PLANNING AMENDMENT

H16/0638/96

Location: Old Police Station
Victoria Street
Spalding
Lincs

Amendment: Amendments to windows and wall to rear of Police Station

ELEVATIONS PR. 3 BEDROOMED HOUSES

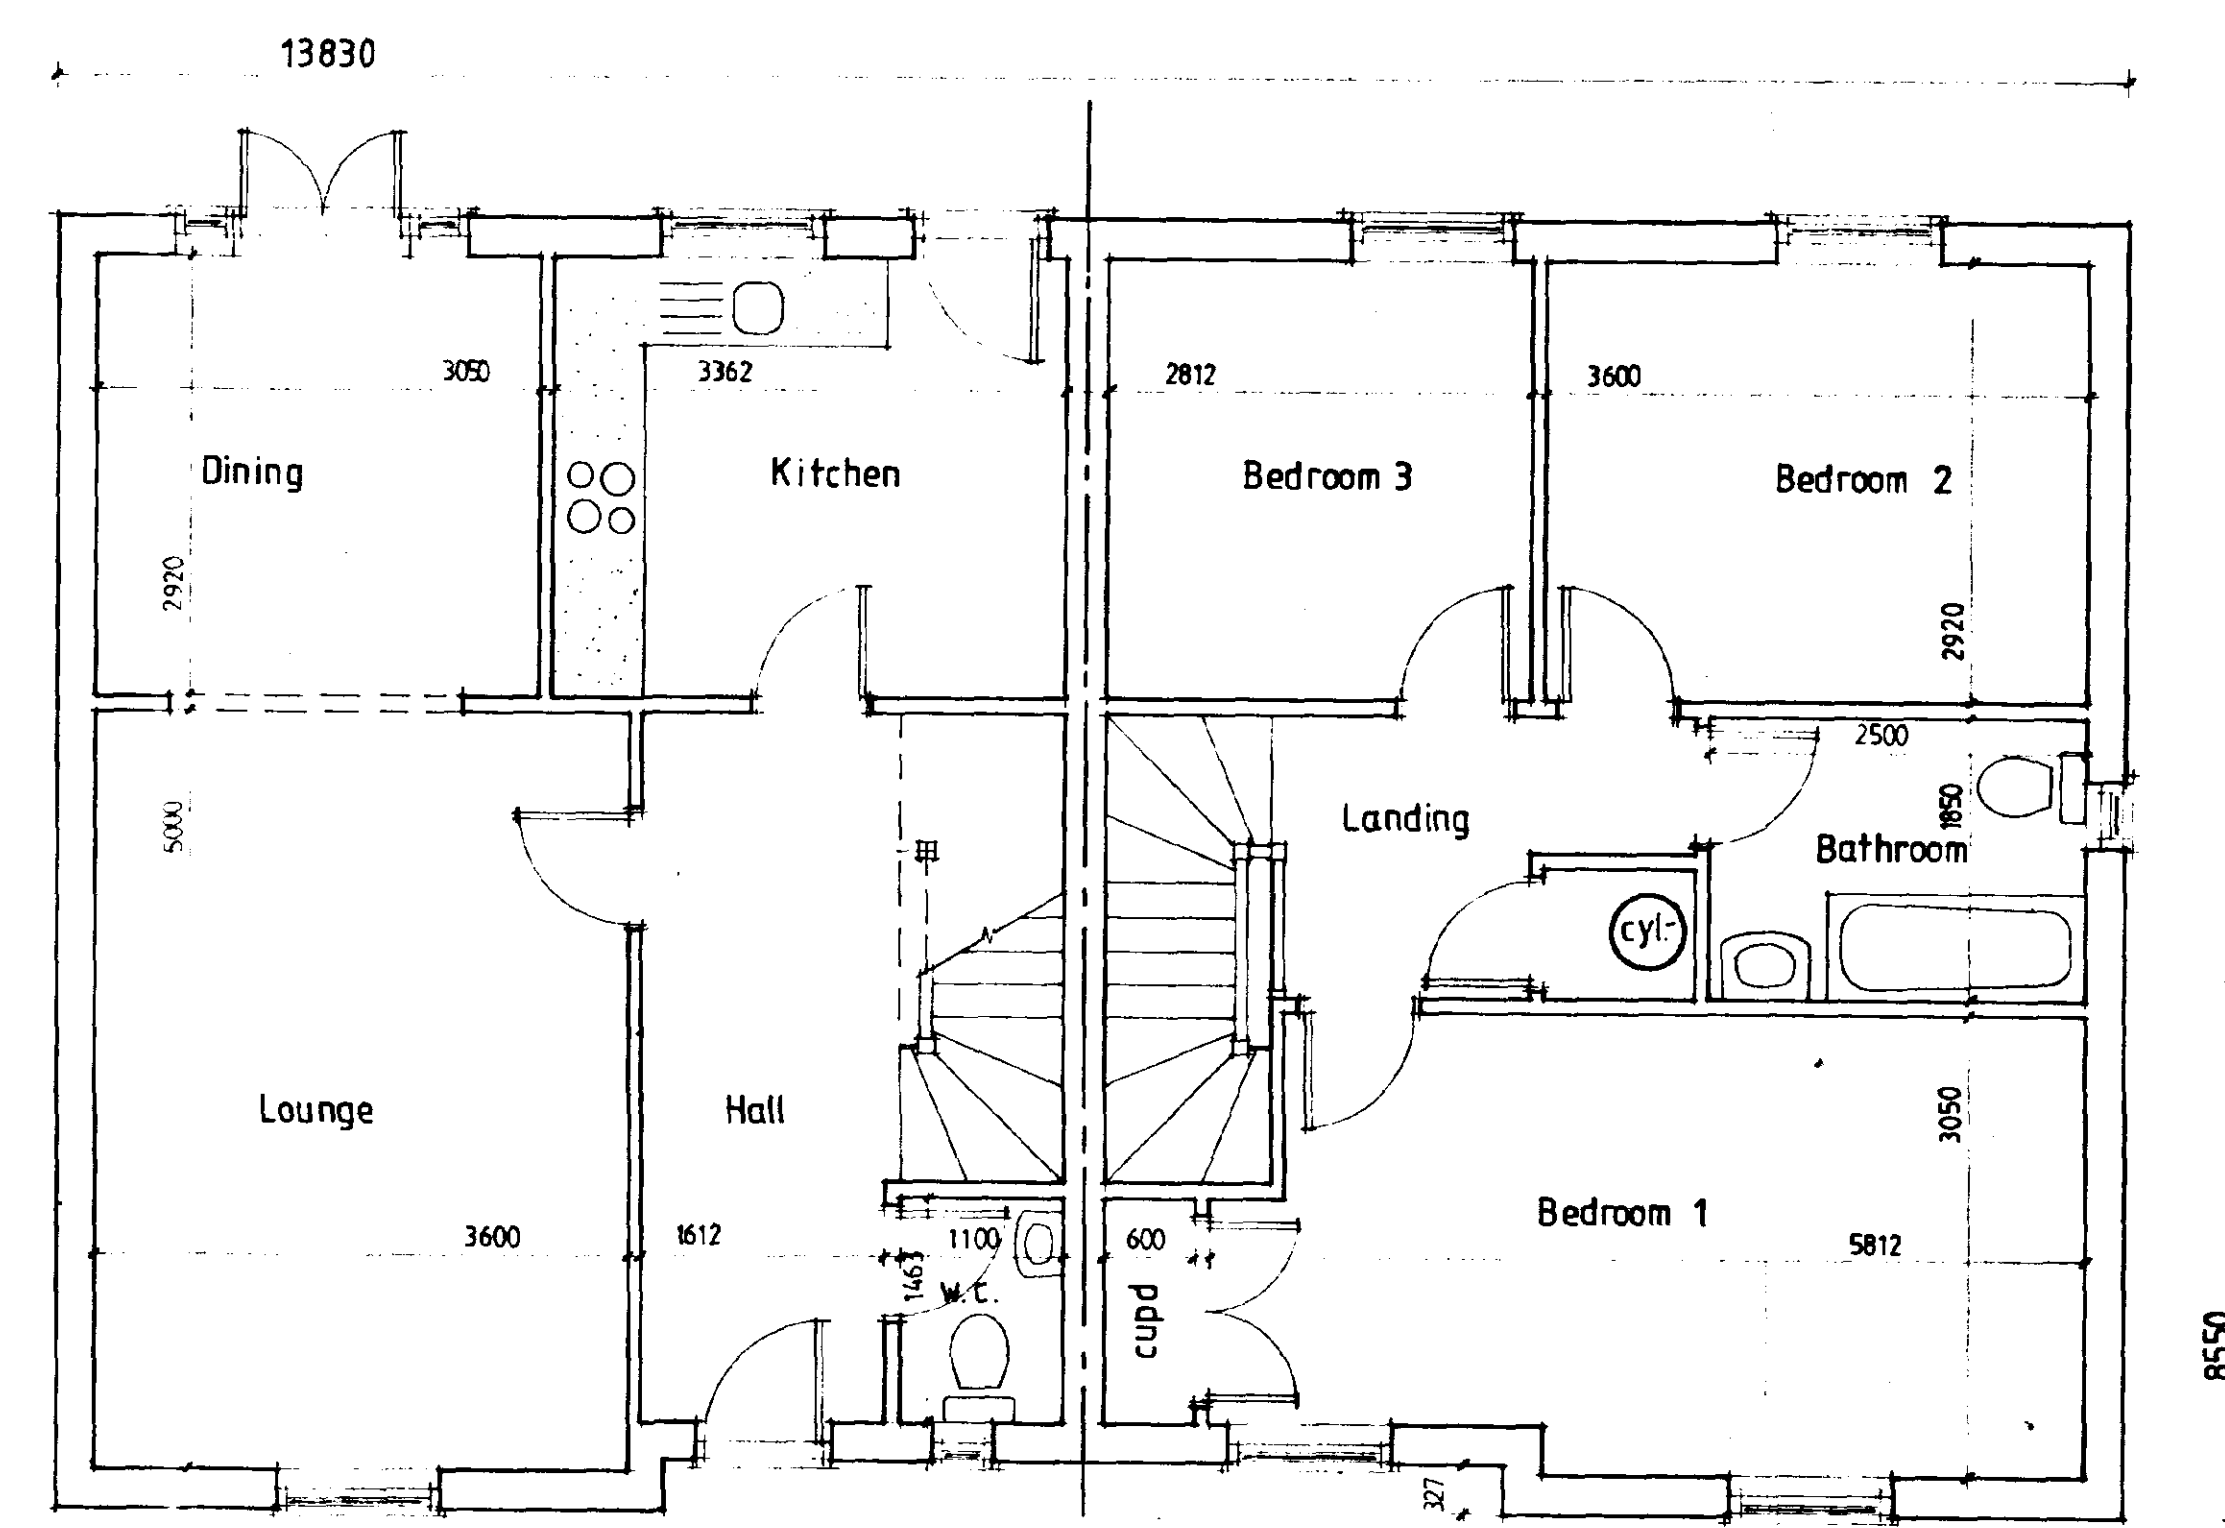
3 BED HOUSES. AMENDED.
WINDOW TYPE TO NEW BUILD
TO BOWTON & PAUL MARGINAL BAR
SLIDING SASH
WALL TO REAR OF POLICE STN.
